**Re: Planning Application 20/0105**

**Address: Barn at Angram Green West Lane Worston BB7 1QB**

**Description: Conversion of agricultural barn/shippon/equipment store into one three-bedroom dwelling and garage for two cars.**

Site Layout Plan Scale 1:500

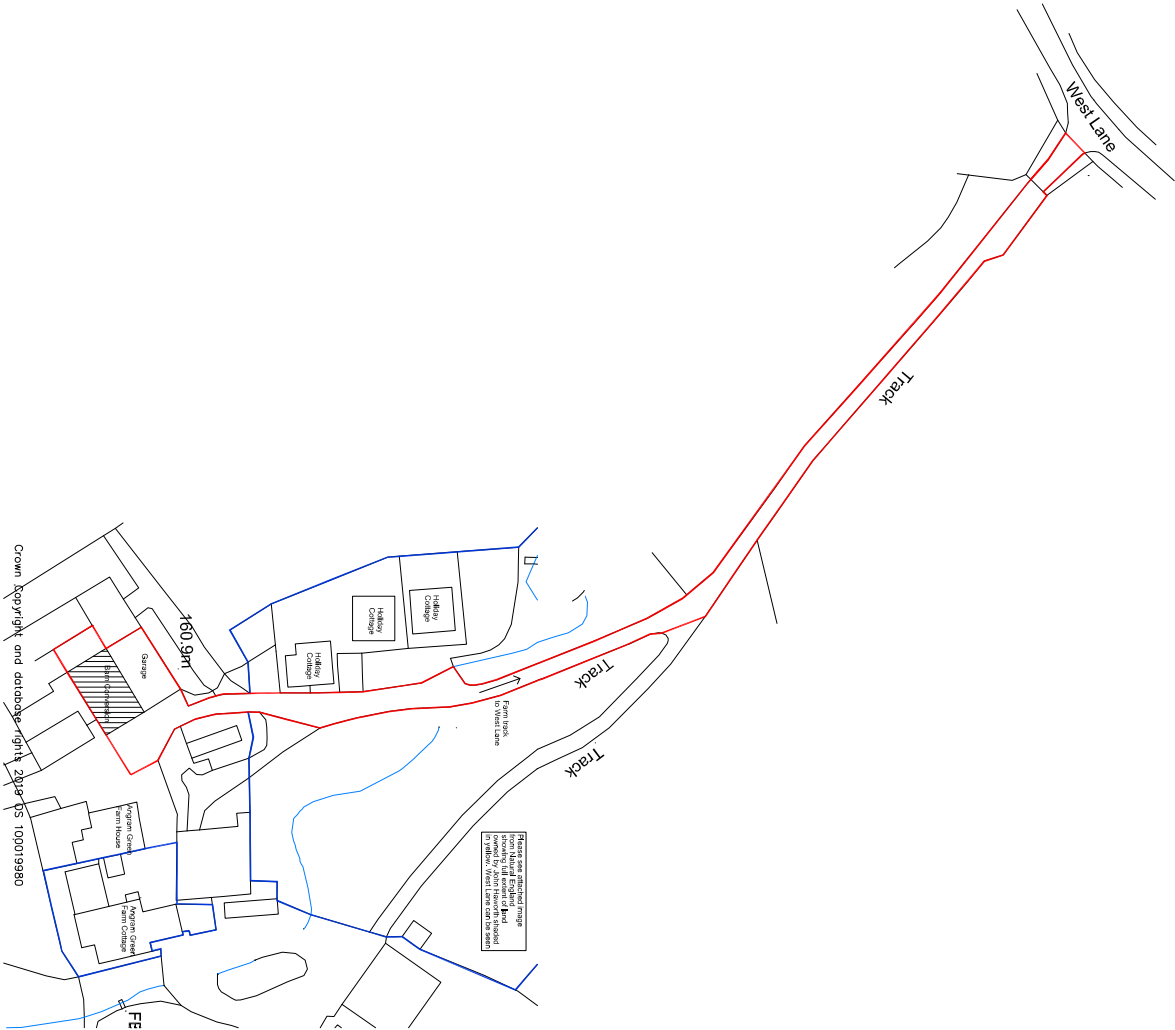
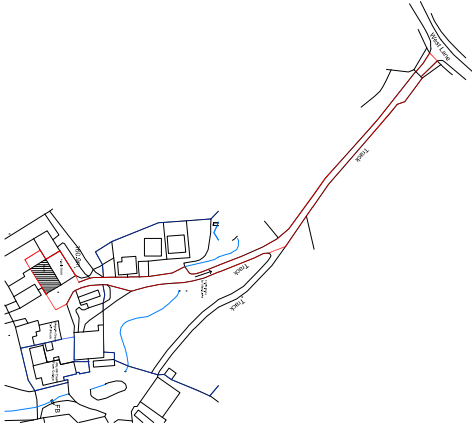
With respect to this application whilst we would not object to the principle of the application, however there is a concern regarding the possible access to the public highway. This access is not shown on any of the supporting documentation for the application.

It is apparent that there is an increased intensification at the farm as a whole and at the site access that is causing some deterioration it and the adjacent adopted highway.

In order to fully support this application we would request that the access is paved in a bound material from the rear edge of the carriageway to prevent debris being carried onto the public highway.

It is expected that this work will need to be carried out as part of a Section 278 agreement.

1. No part of the development shall be occupied until all the highway works at the junction with the adopted highway have been constructed in accordance with a scheme that shall be submitted to and approved by the Local Planning Authority in consultation with the Highway Authority as part of a section 278 agreement, under the Highways Act 1980. **Reasons:** In order to satisfy the Local Planning Authority and Highway Authority that the final details of the highway scheme/works are acceptable before work commences on site and to enable all construction traffic to enter and leave the premises in a safe manner without causing a hazard to other road users.
